STATE OF NORTH CAROLINA
DEPARTMENT OF TRANSPORTATION

Addendum No. 1

RE: Contract # C204284

14 SECTIONS OF US-29 AND RAMPS.

**TYPICAL SECTION NO. 1**

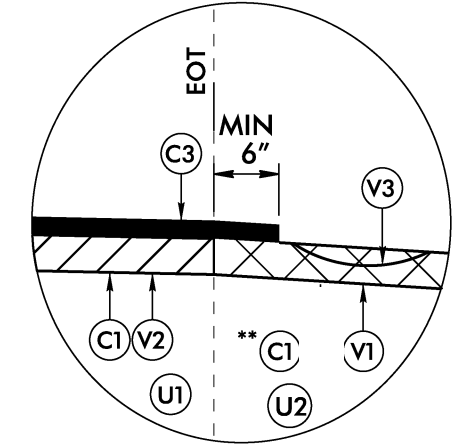
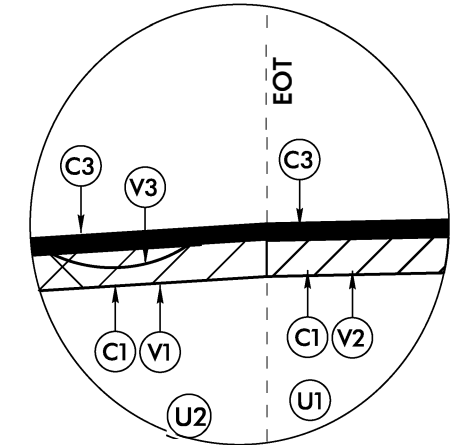
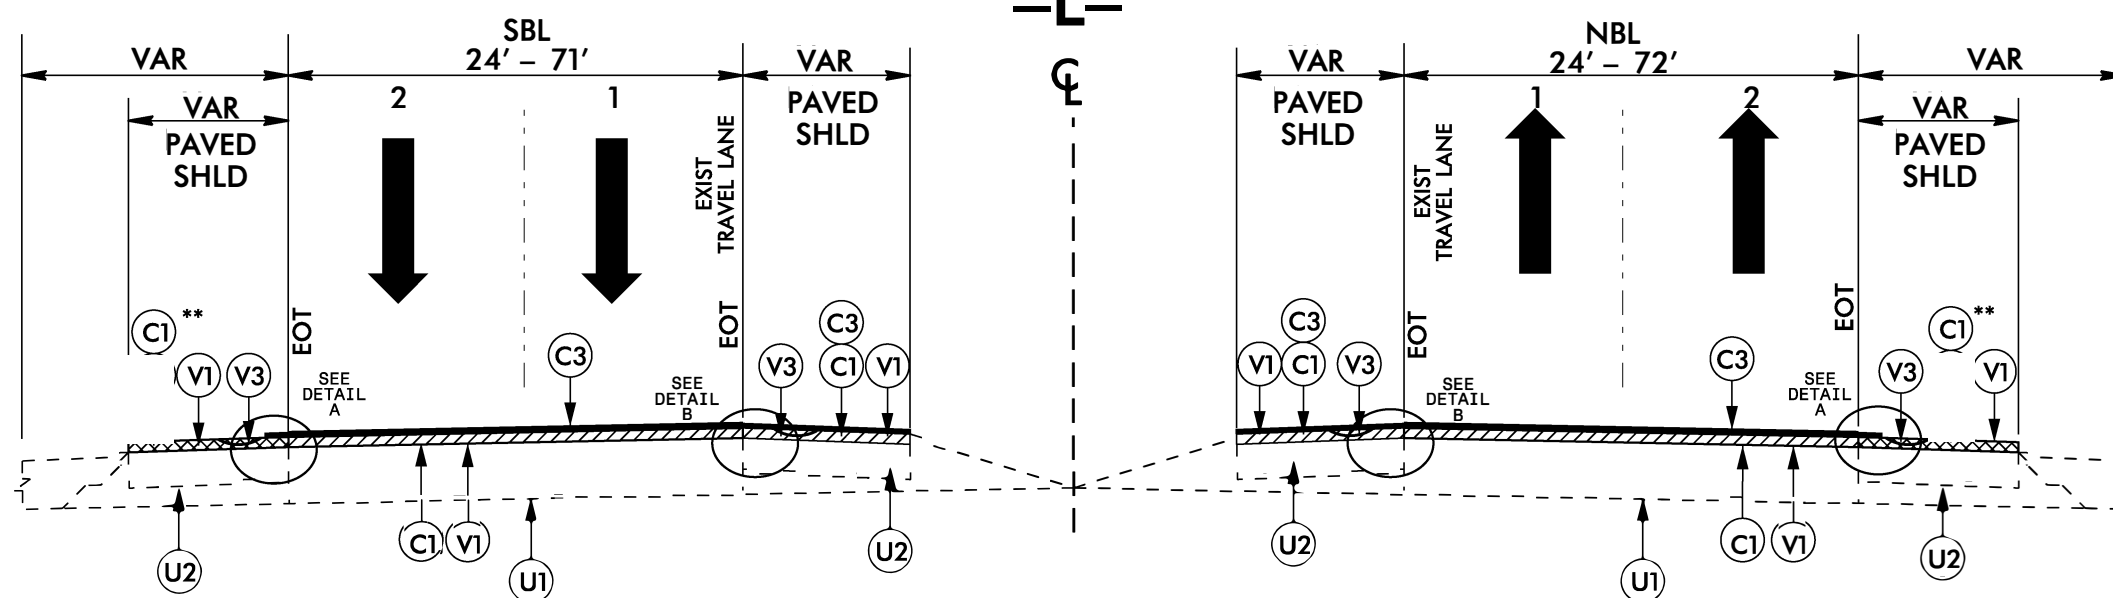
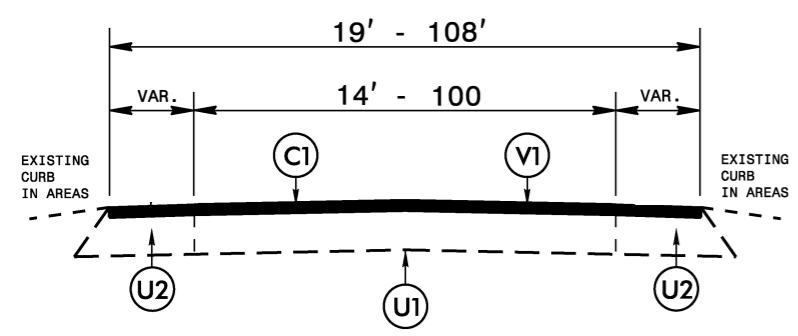
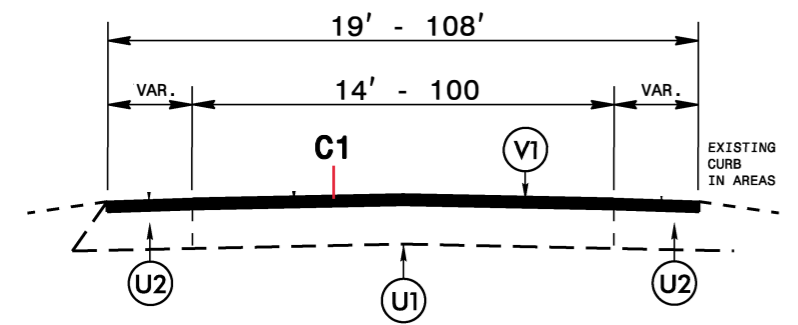
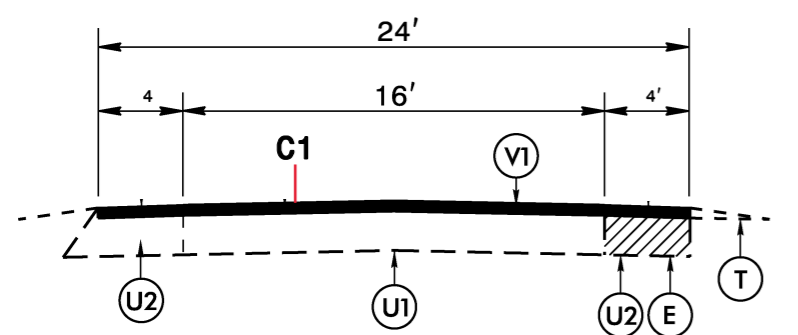
Sheet No.	Revision
3 & 4	Removed S9.5B mix from typical sections
6	Revised Summary of Quantities to reflect quantity changes shown below
